Arboricultural Report

12 - 18 Pield
Heath Road,
Uxbridge UB8
3NF

March 2025

Ref 22-8959
Rev 1

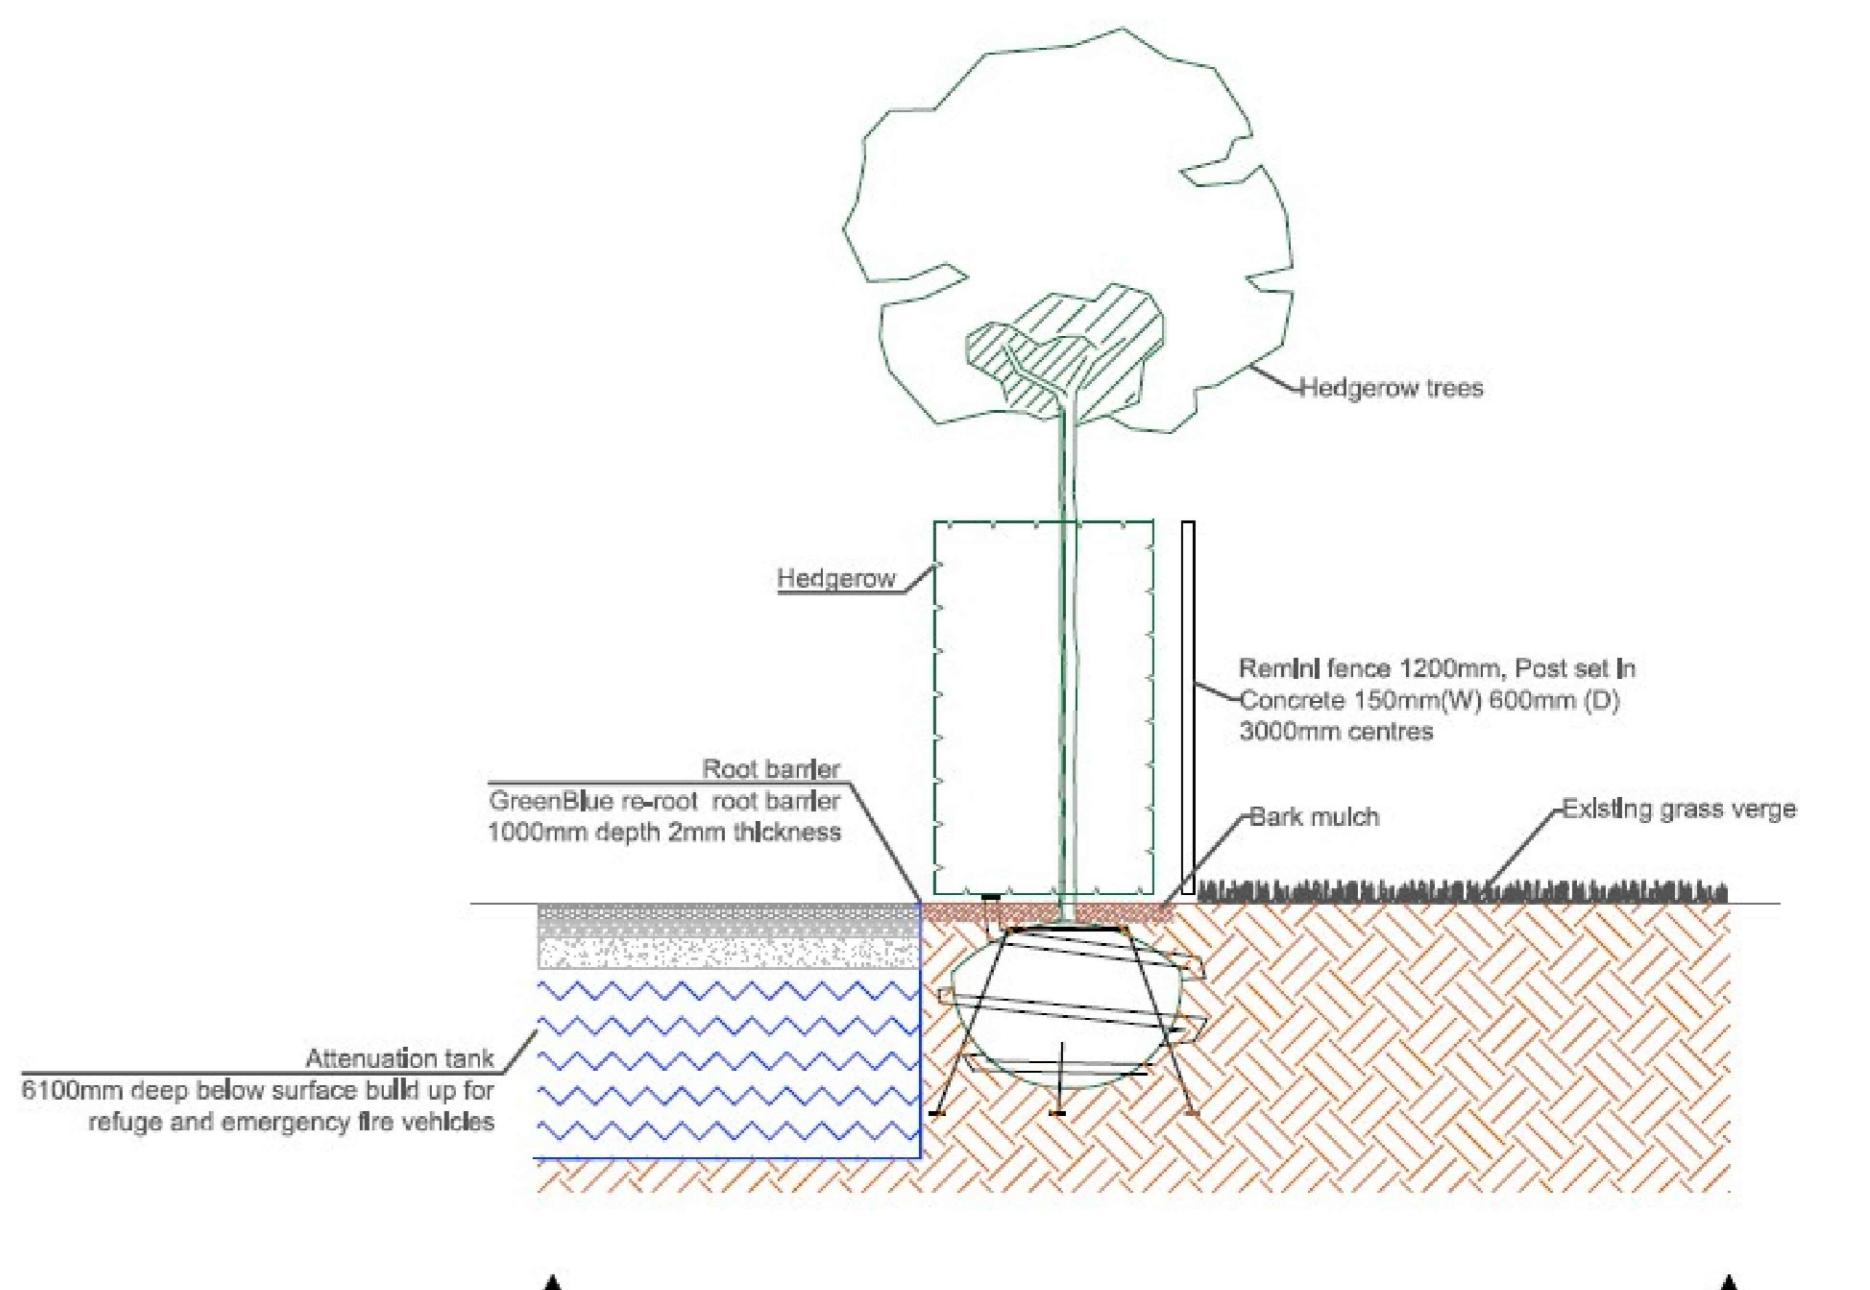
- The southern boundary trees should be extended the whole length of the southern edge within the hedgerow. The extent on the tree trench is required to be shown on the drawing with construction detail, to ensure the appropriate soil volume is supplied for these trees to reach maturity.

- The proposed trees within the garden seem planted too close. The plan needs to show the mature canopy sizes to ensure the spacing is acceptable.

This has been done as much as possible in the updated proposed tree planting plan. A linear tree trench will be created with tree crates and structured soil

The proposed planting plan has been updated to show canopies after 25 years in green circles.

The species chosen are generally small and will add valuable shade to this garden.
